Nick Donoghue,
Network Rail - Planning,
1 Eversholt Street,
London, NW1 2DN

Network Rail Consultation Response: F/4/20/OUT - Land at Ford Airfield Ford, West Sussex

TITLE:  
**FORD AIRFIELD  
PUBLIC RIGHTS OF WAY PLAN**

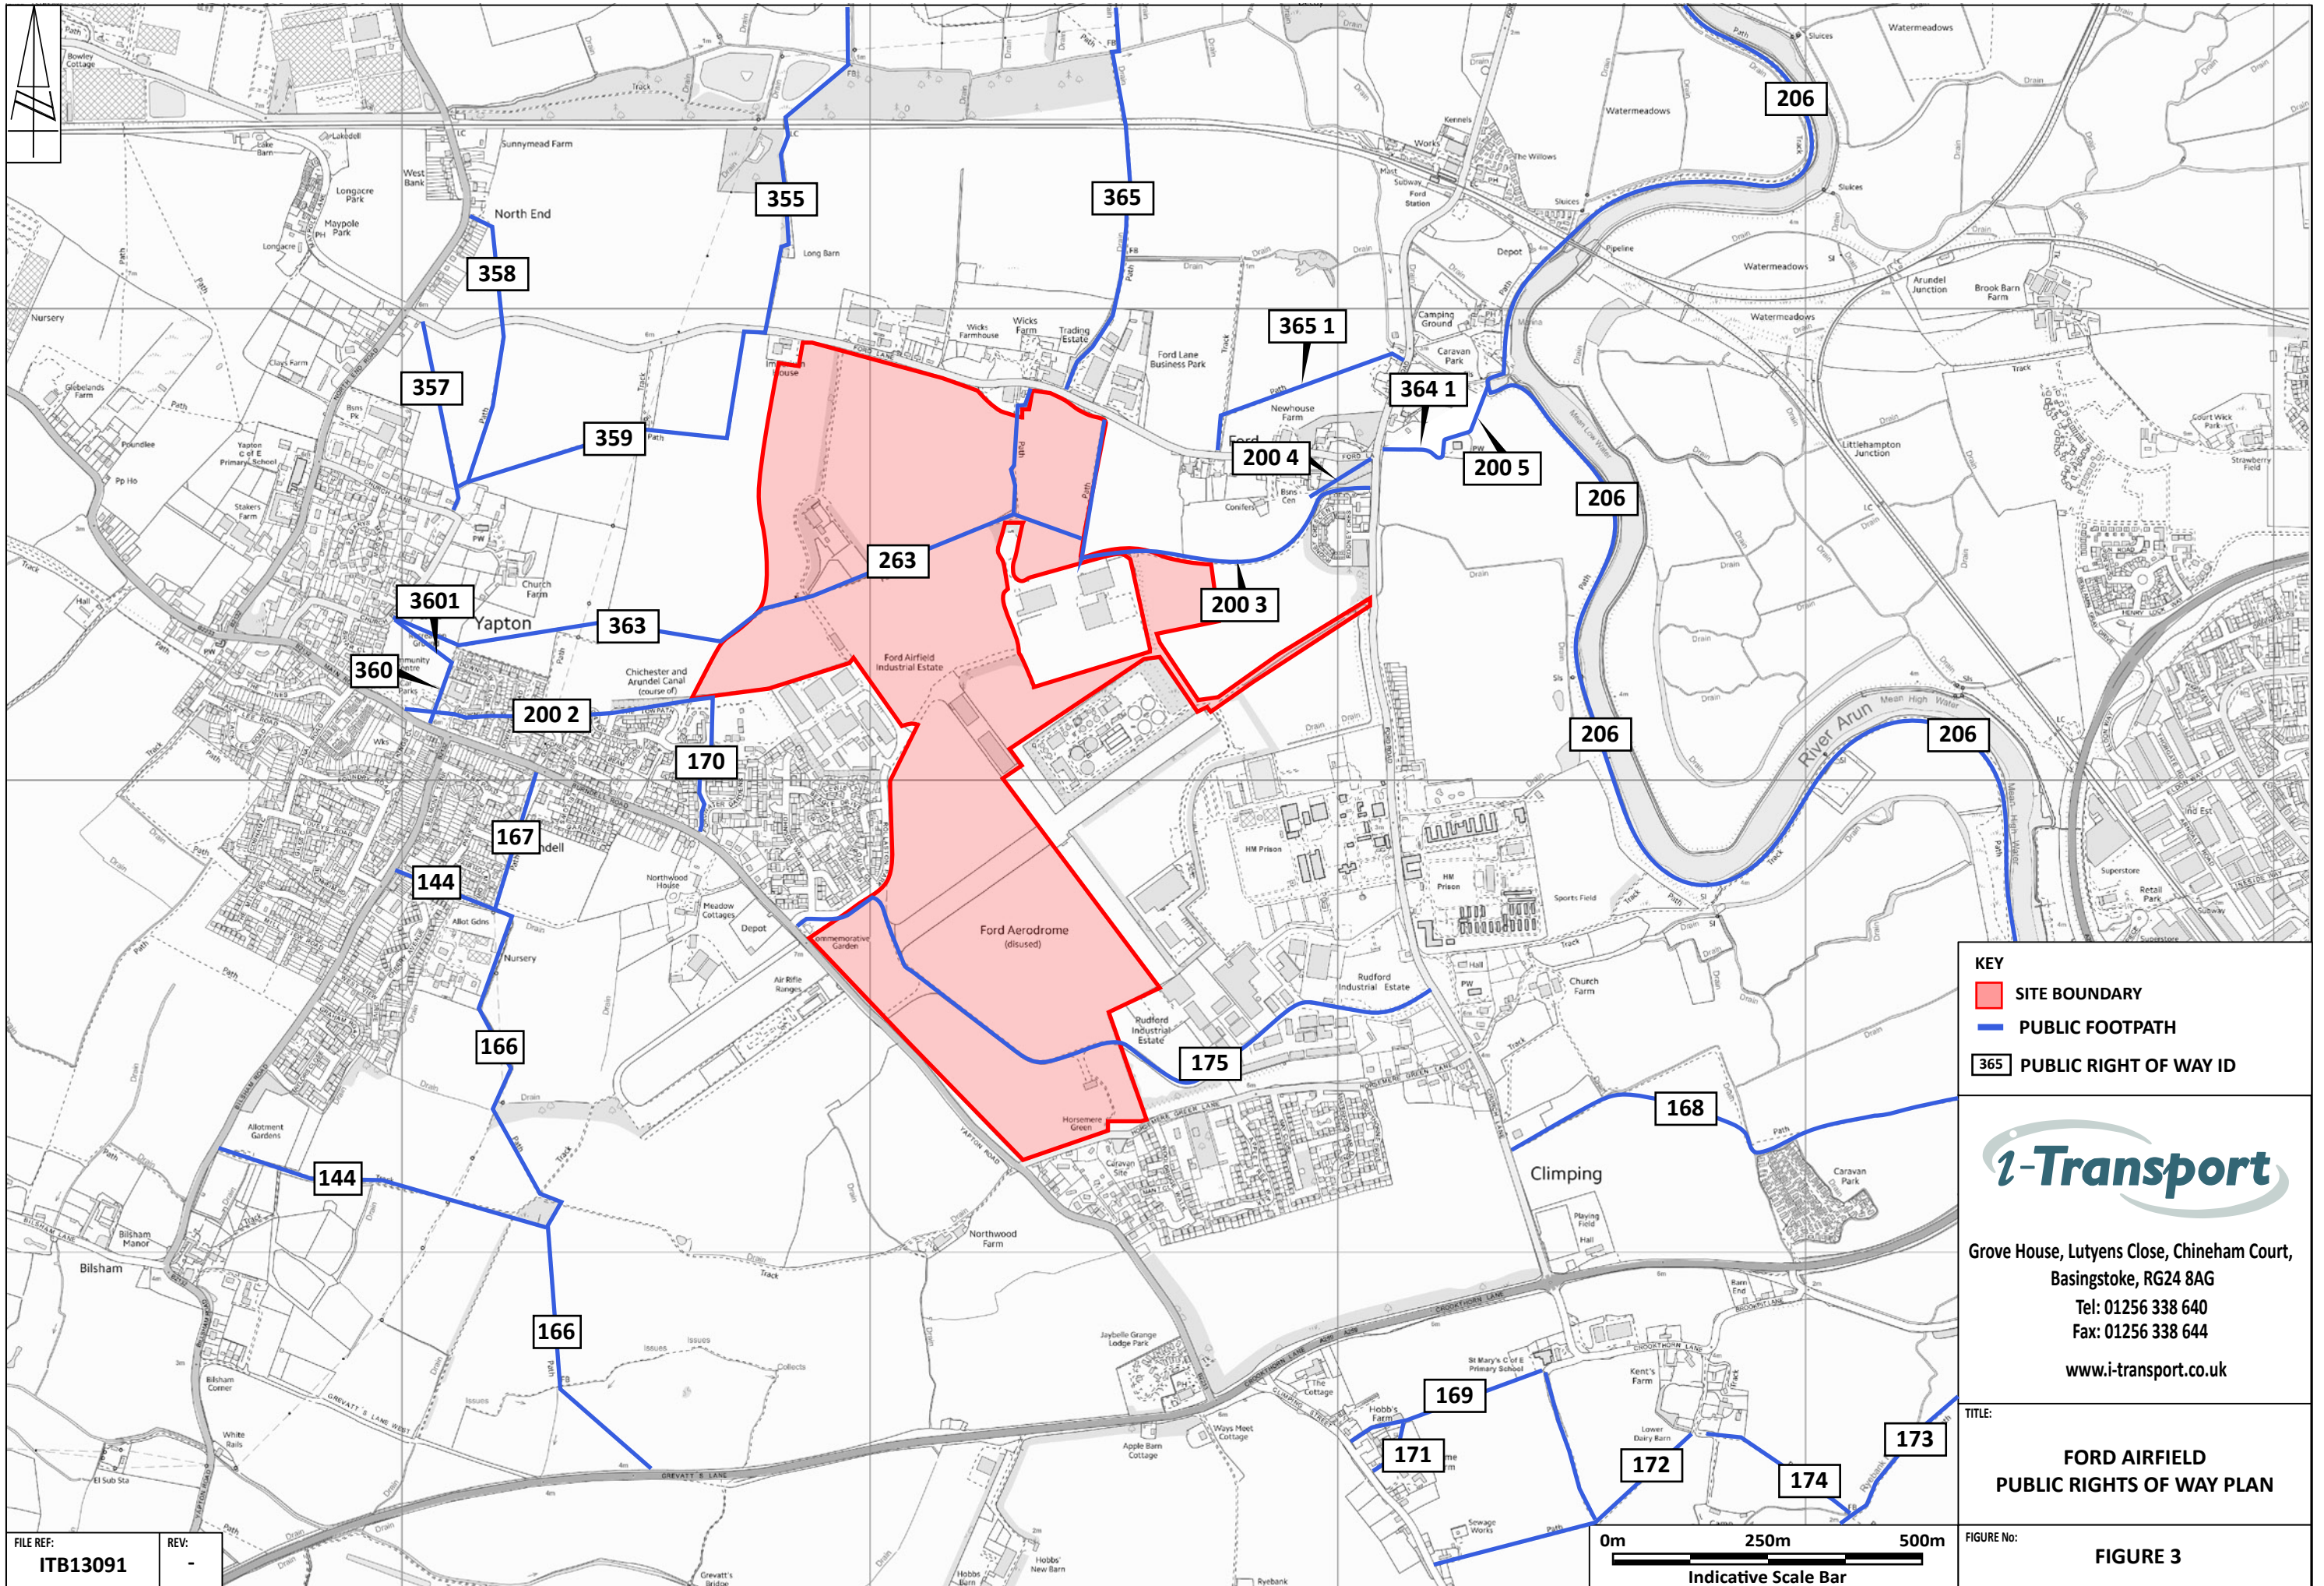
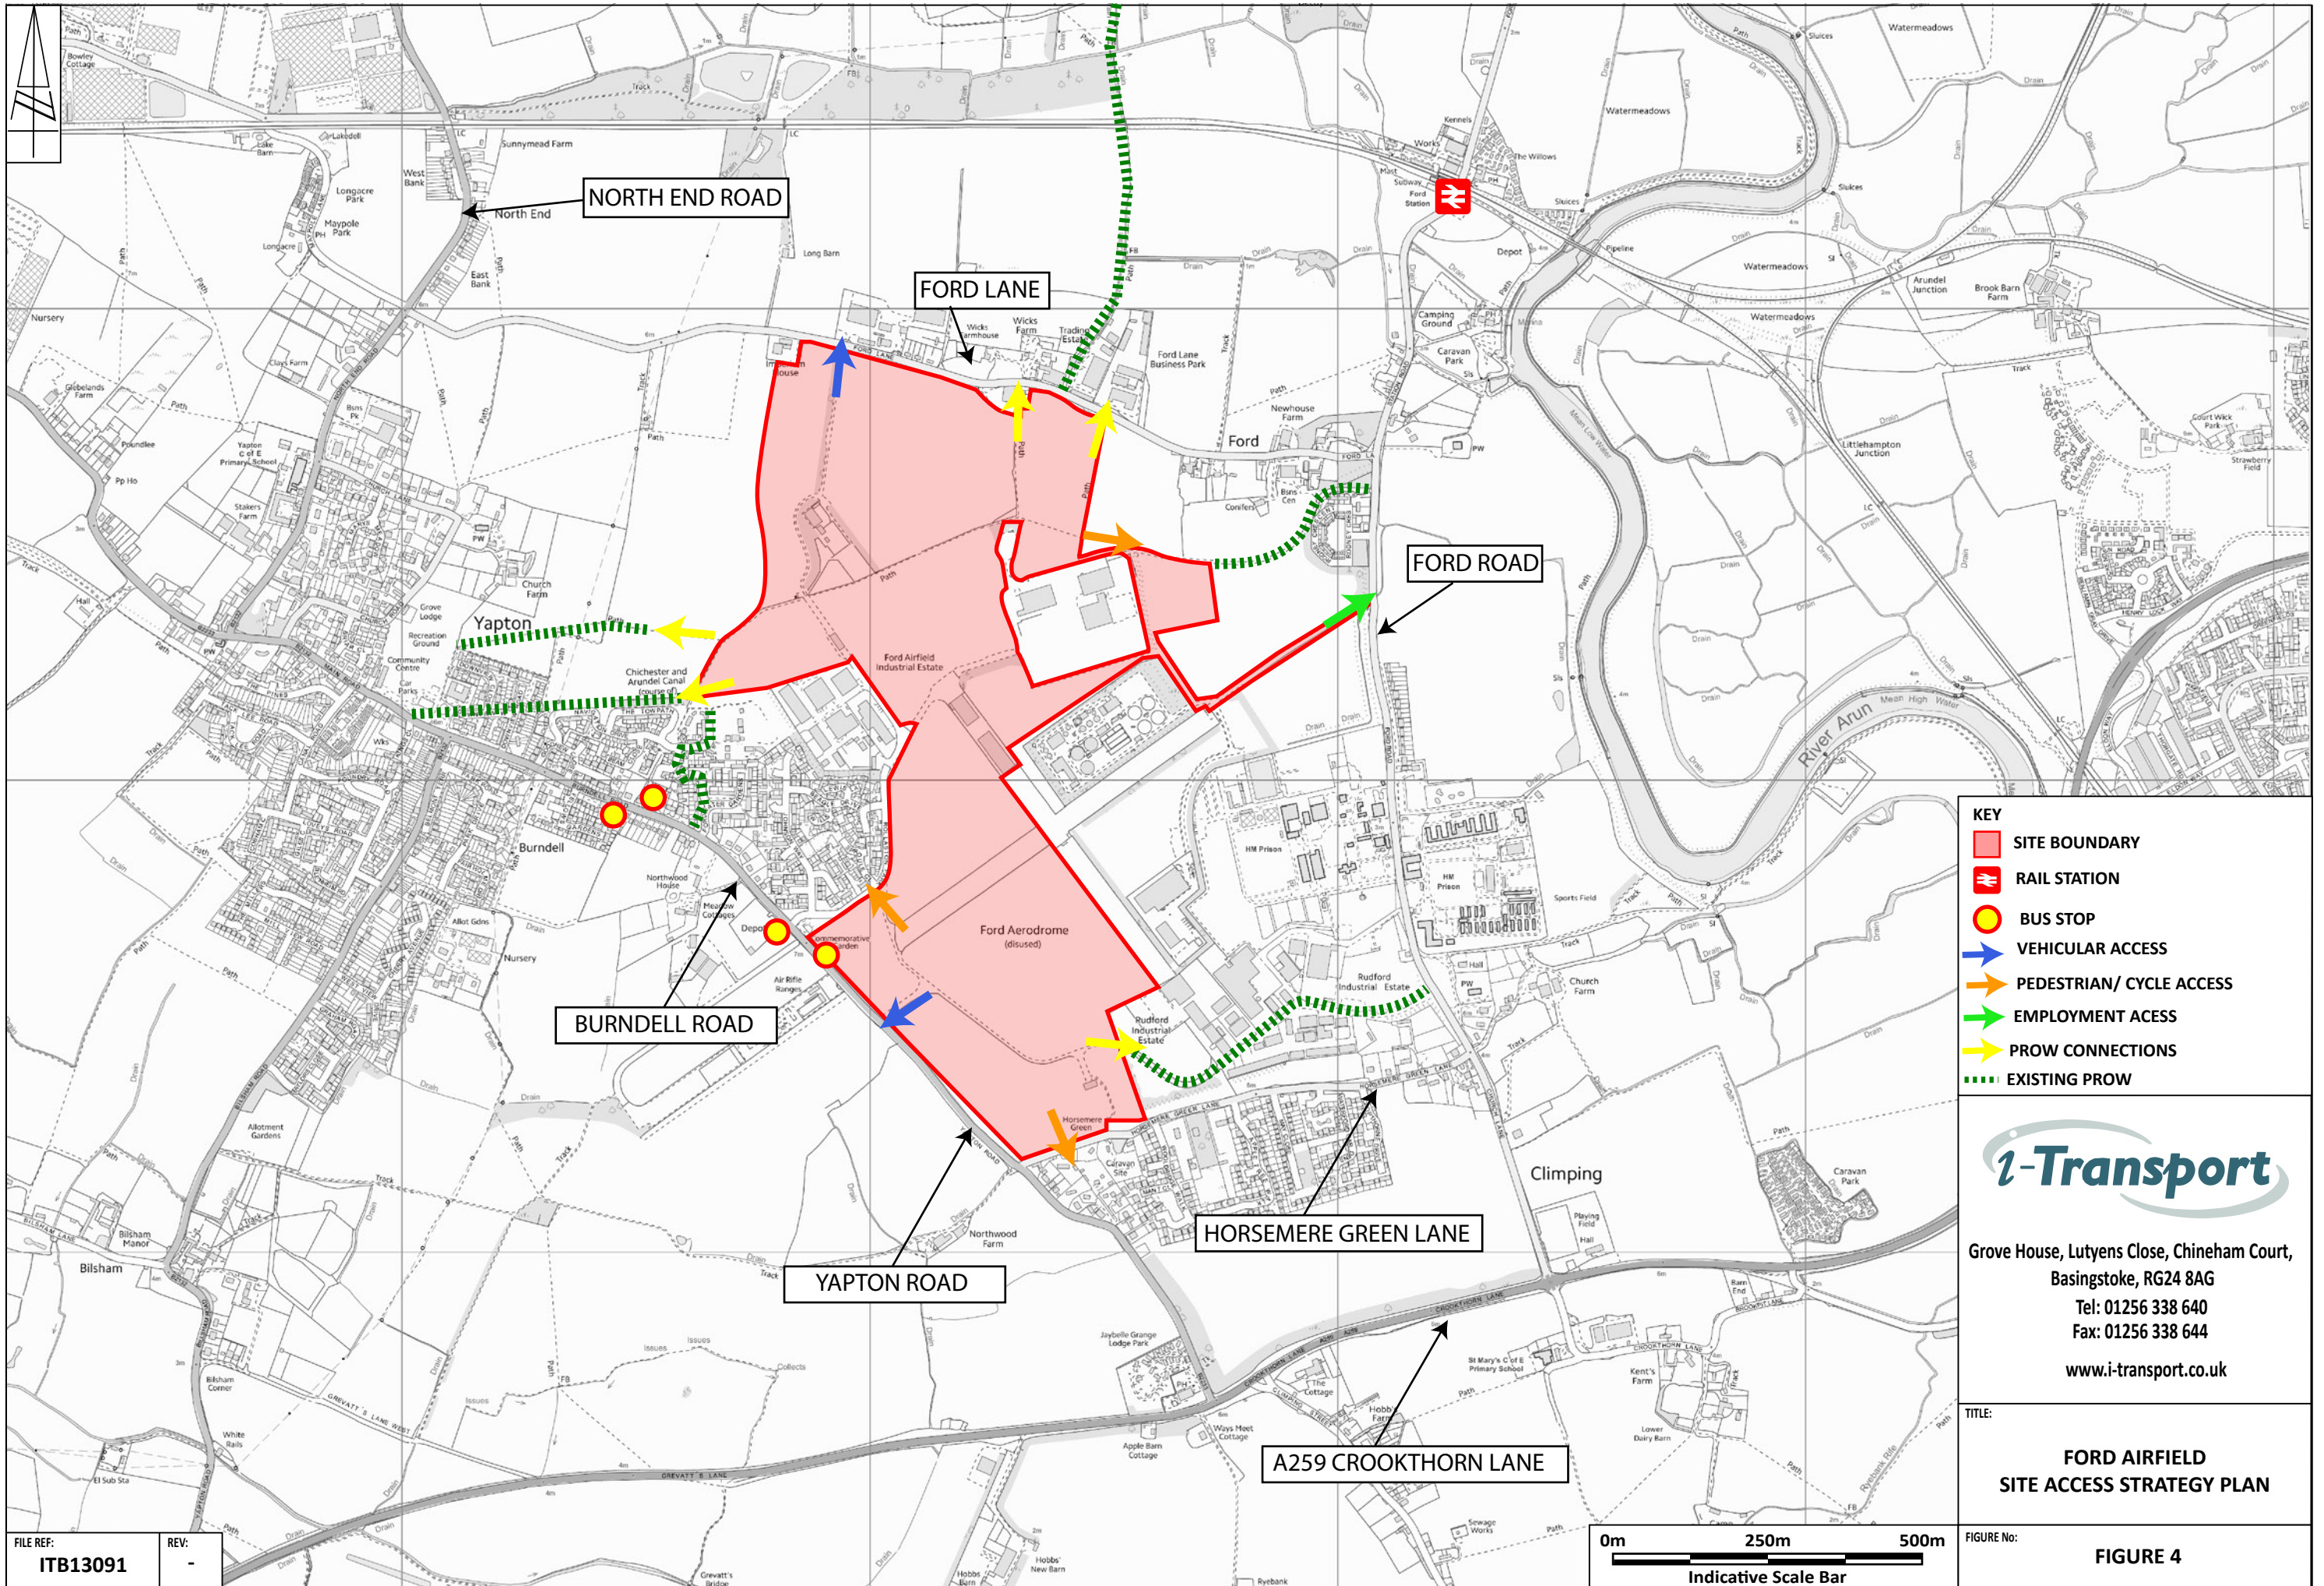
Lake lane, Hoe lane and Long barn PF level crossings are shown on the proposed development plan to be integrated into the development for recreational access. With the current protection measures in place at these foot crossings, any significant rise in the number of uses would create an unacceptable level of risk when assessed in relation to the number of trains (308 per day) that pass over these crossings.

Jacobs ladder and Langmeads farm foot crossings are also in the vicinity of the development and would need to be included in any comprehensive survey regarding increased risk at crossings in the area.

If the development is implemented, Network Rail's preferred mitigation would be to close the footpath level crossings, completely removing the risk to the rail network. However, the mechanism and practicality for the footpath level crossing closures still needs to be assessed. If closure is not feasible, Network Rail may require mitigation at these footpath crossings to reduce the risk to an acceptable level.
